37 Inverness St.

Duplex

RE: Application for Minor Site Plan, 37 Inverness Street
(CBL #168 F008001) (ID#2006-0130)

I am in receipt of your resubmission for the 37 Inverness Street Duplex. The revised site plan was reviewed once again and here are the final comments that need to be addressed before I can sign off on this application.

**MINOR SITE PLAN FOR A PROPOSED DUPLEX  
INVERNESS STREET PORTLAND, MAINE**

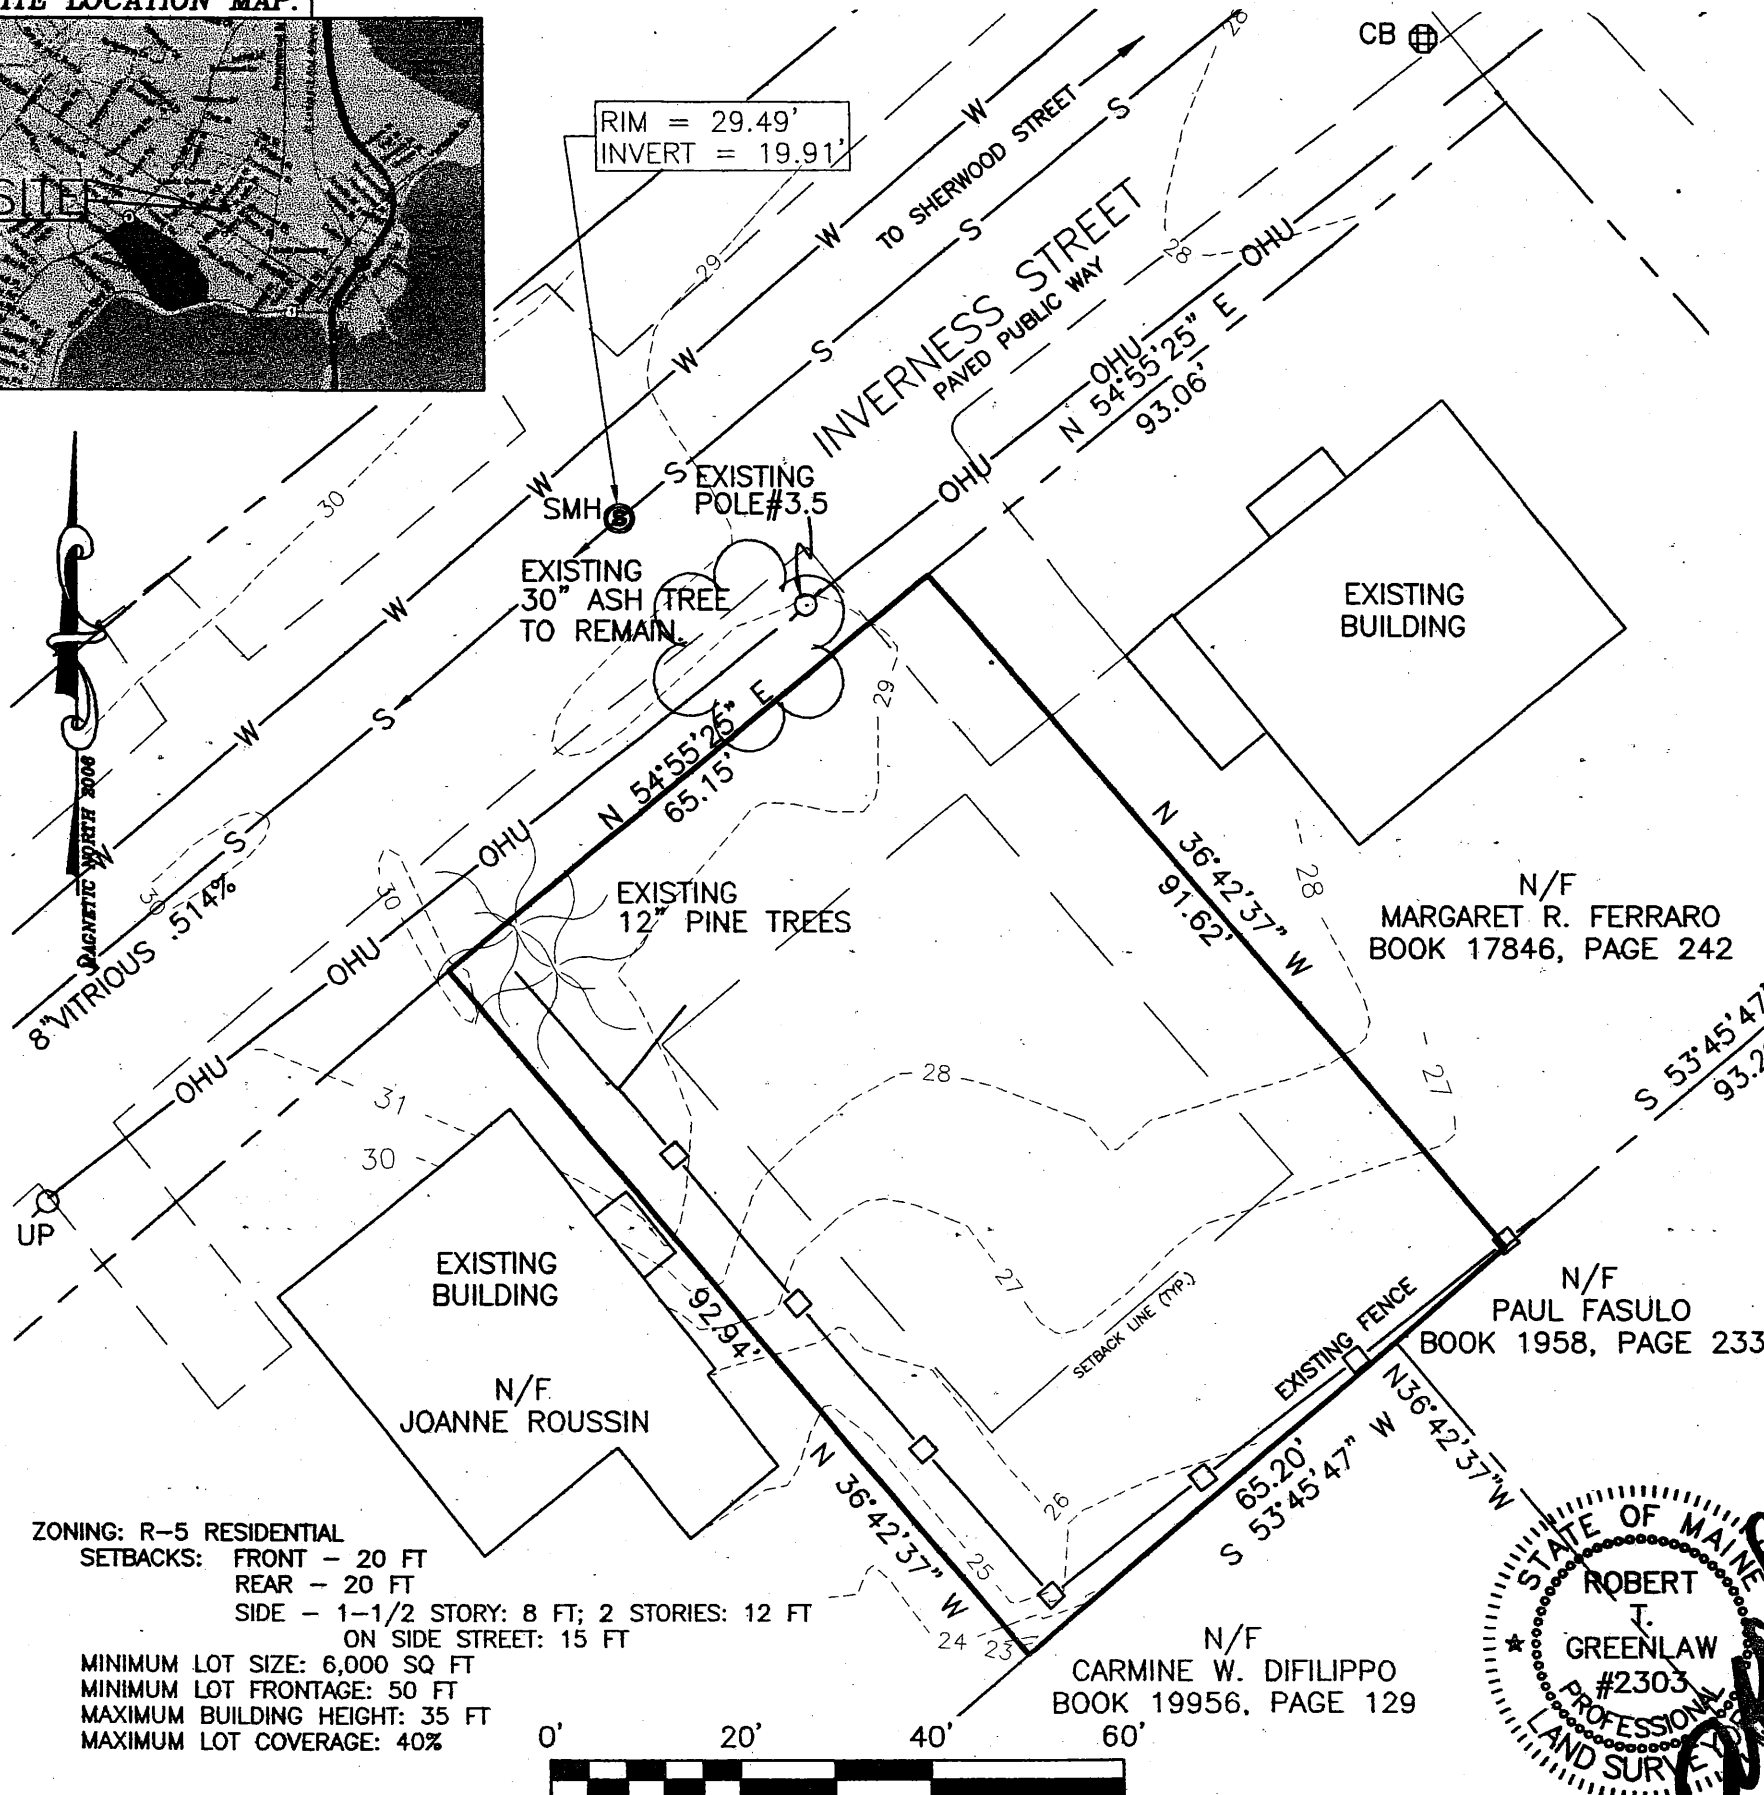
1. Please submit Curbing and Sidewalk waiver.
2. Street trees- if none of the existing trees can be preserved then two additional trees could be planted the back yard to get a total of four trees. You also need to provide on the site, the size and type of plants to be used. If there are no plans to plant trees in the back then please submit a waiver

3. Just an FYI- the driveway to the east does not have a 20' spacing to the existing drive (which is required) but DPW have waived this requirement.
4. Per our phone conversation, I had expressed that the City's Technical and Design Standards and Guidelines had stated that the minimum driveway width should be twelve (12) feet. The site plan does show the driveway width (at entrance) to be 12' but the entire length of the driveway does not have to be 12' wide. Therefore you can maintain a 5-foot setback from the property line the entire length of the property line.

5. In an email for Marge Schmuckal, the following needs to be addressed: Are the rear decks going to be 4' x 6' or 10' x 10' as shown on the most recent plans you gave us. The applicant came in to reduce the rear decks to 4' x 6' and sketched them in on our previous plans. Please show the decks to read 4' x 6'.

REAR ELEVATION

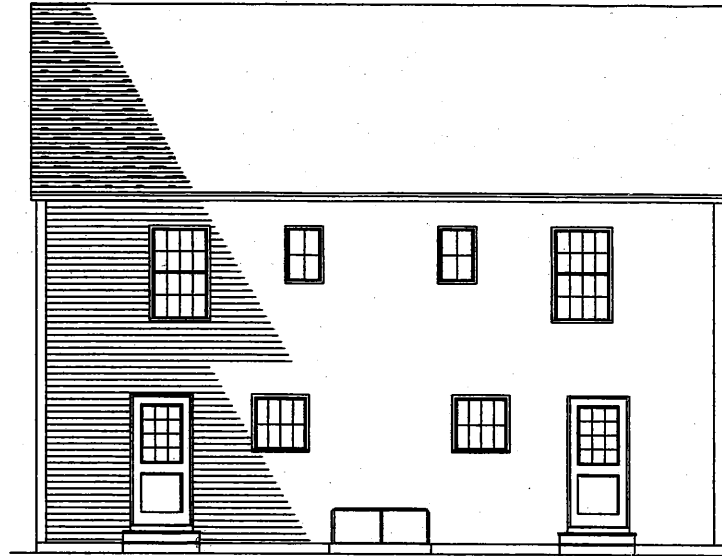
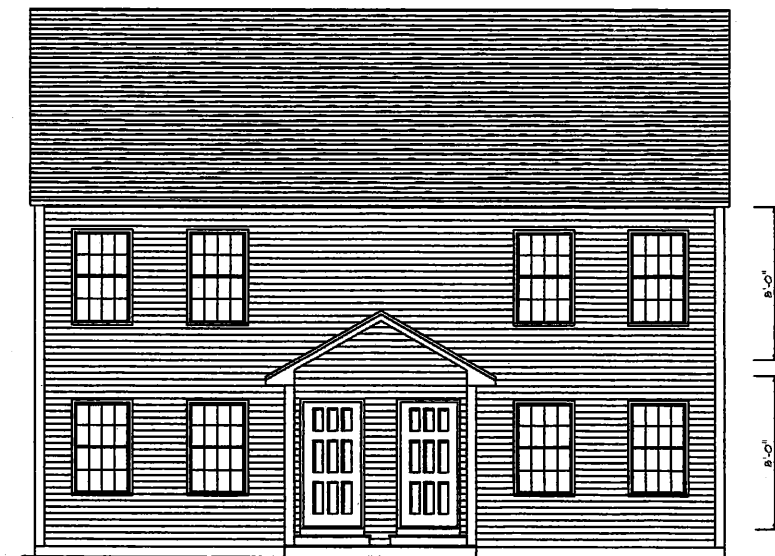
7. A narrative needs to be provided the addresses the following design standards:
 - i. Roof Pitch: A minimum of 7:12 roof pitch is required for two-family buildings.
